**Yiribana Logistics Estate (SSD-10272349)
Response to Submissions Report**

I refer to the Department of Planning, Industry and Environment's (the Department's) letter of 22 October 2021, which advised the Department would be providing comments following the exhibition of the above proposal.

Attachment 1

DRAWING	DOCUMENT TITLE
MP 00	Location Plan / Cover sheet
MP 01	SSDA Masterplan
MP 02	Estate Works Staging Plan
MP 03	Subdivision Plan
MP 04	Site Analysis Plan
MP 05	Zoning Plan
MP 06	Signage Plan
MP 07	Fire Protection Plan
MP 08	Vegetation Management Plan
MP 09	Fencing Management Plan

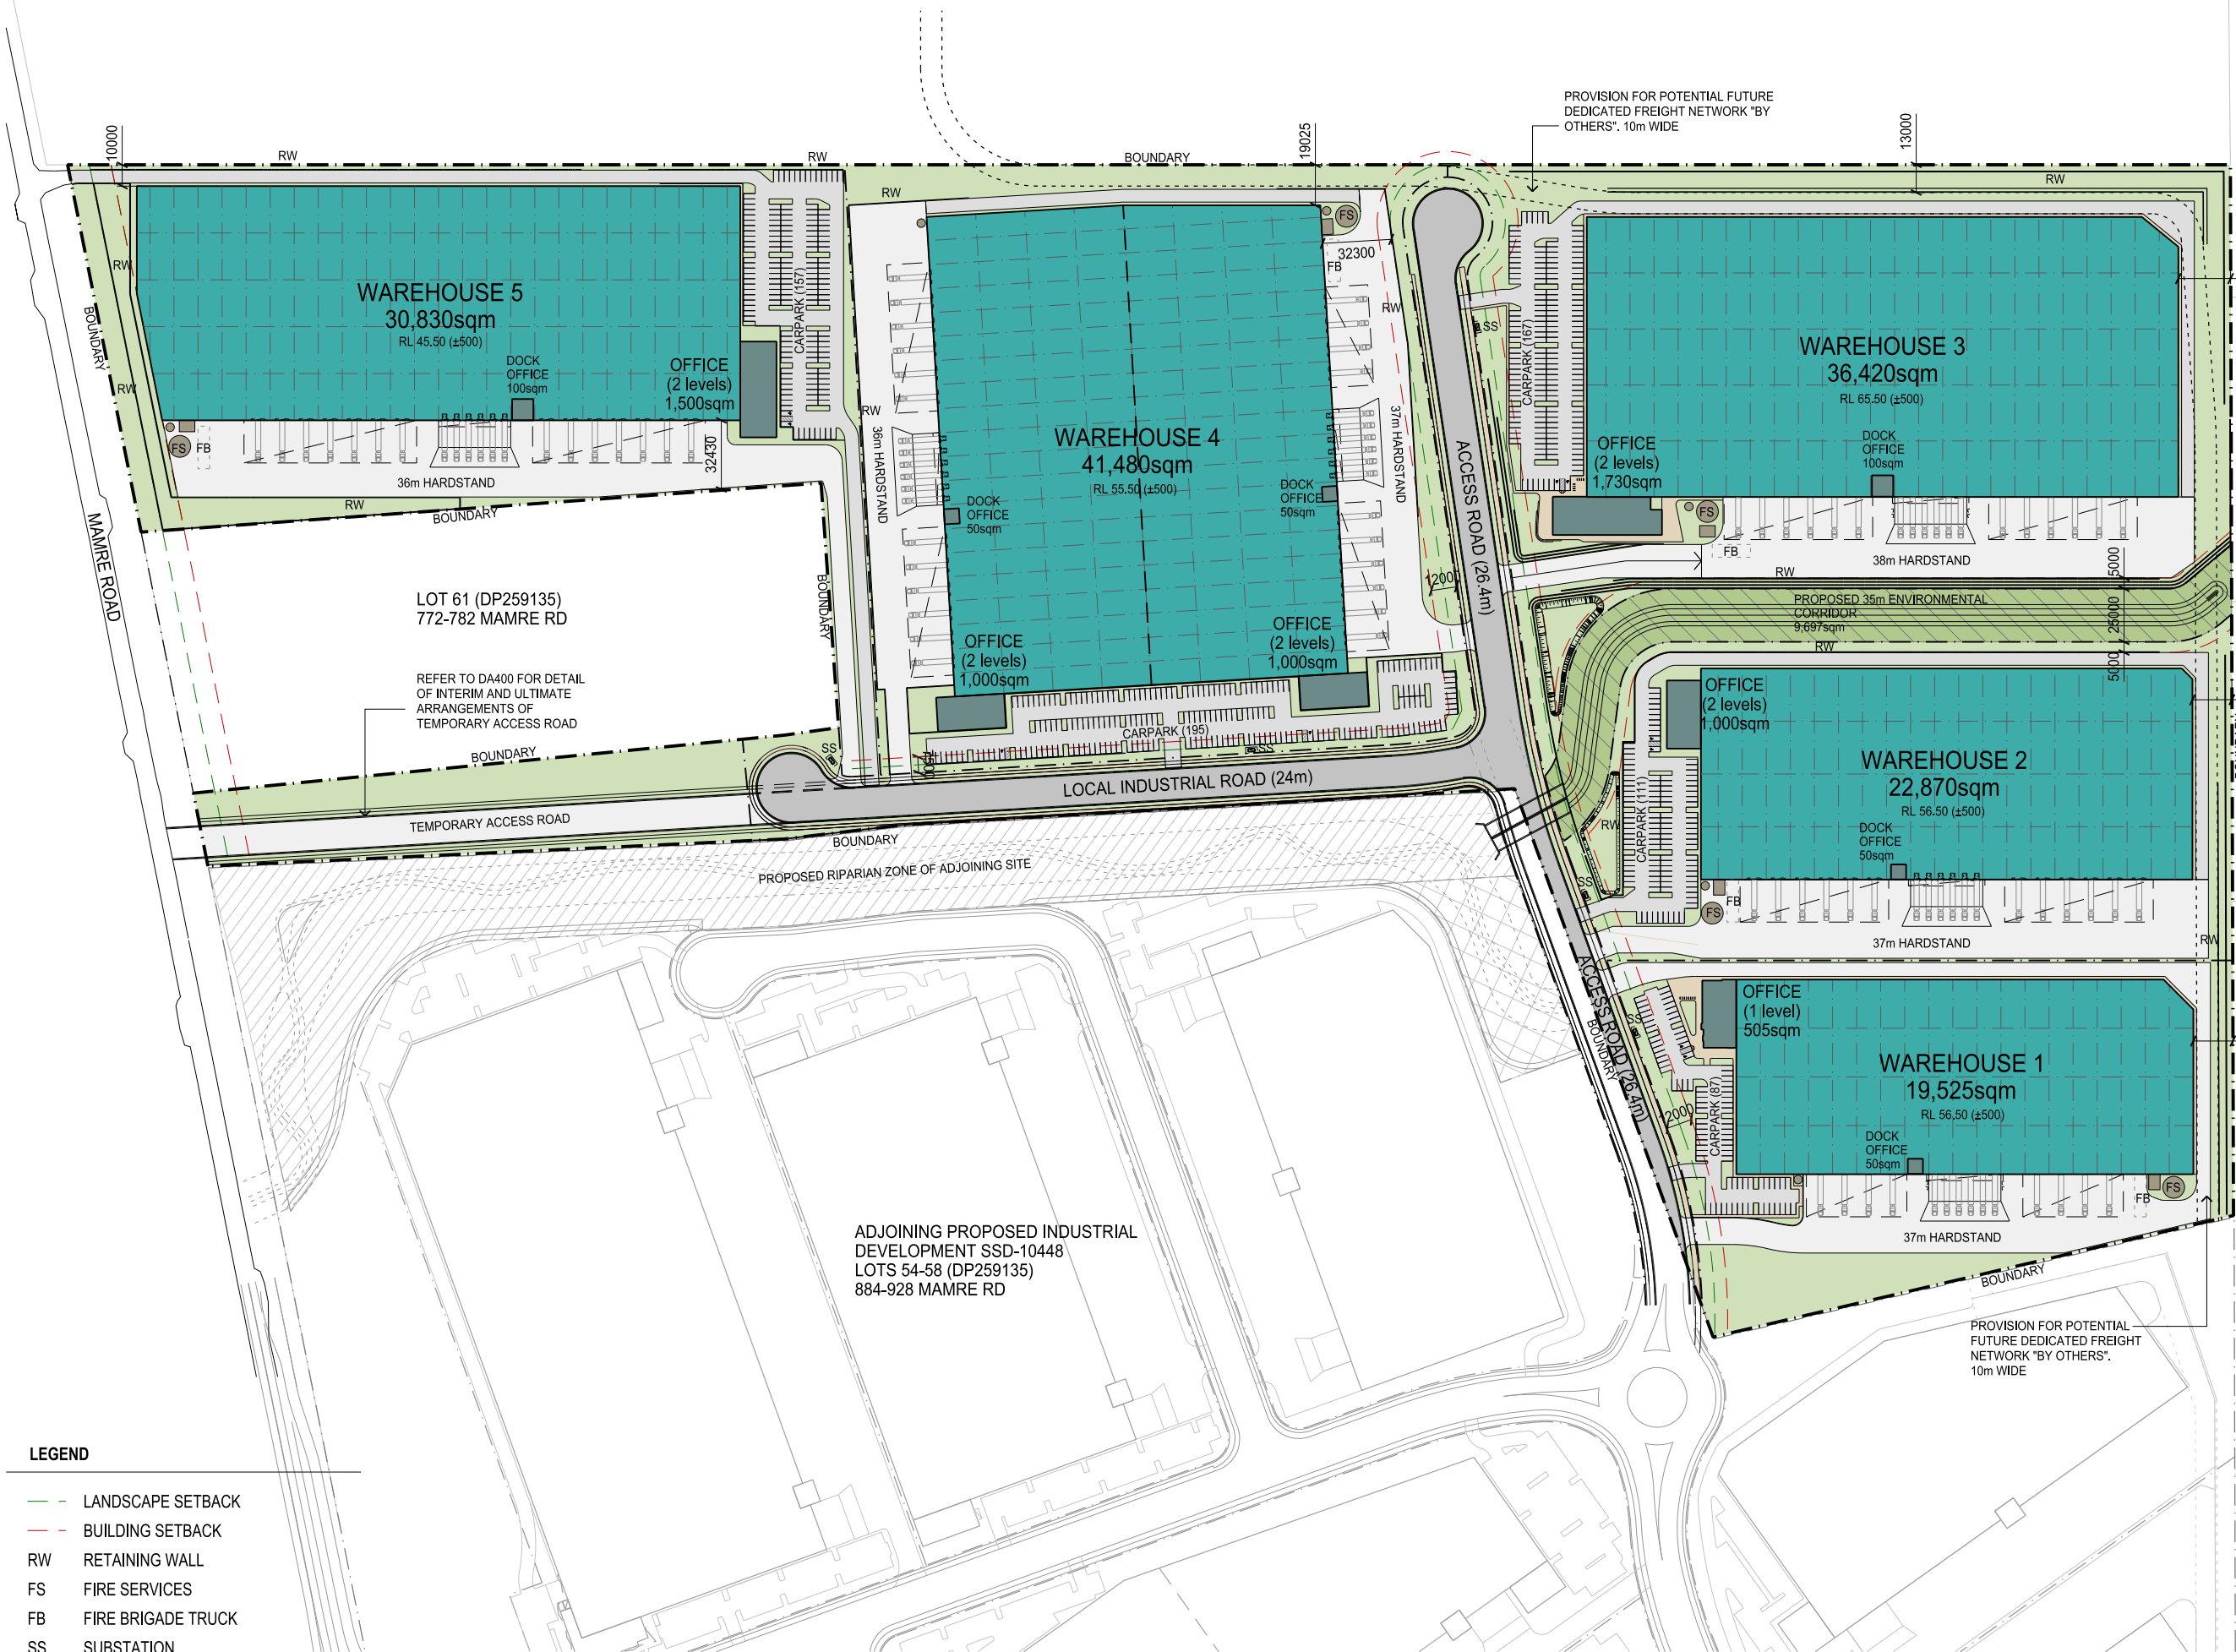
- Clarification is required on the access arrangements for Warehouse 1. The site layout plans depict a half road along the frontage of proposed Warehouse 1. Will this half road be designed to accommodate two-way operational traffic from Warehouse 1 until the full road is delivered? It is unclear how access to Warehouse 1 for both construction and operational traffic will be achieved prior to the delivery of the full North-South Road.

- Clarification on the relationship between proposed final site levels between this proposal and the adjacent sites is required.
- The pad level for Warehouse 3 is 9 m and 10 m higher than the pad levels for Warehouse 2 and Warehouse 4, respectively. Given the large difference in heights, clarification is sought on the access arrangements to Warehouse 3. Provide further information to demonstrate the access arrangements for Warehouse 3 can accommodate the largest vehicle that will access the site.
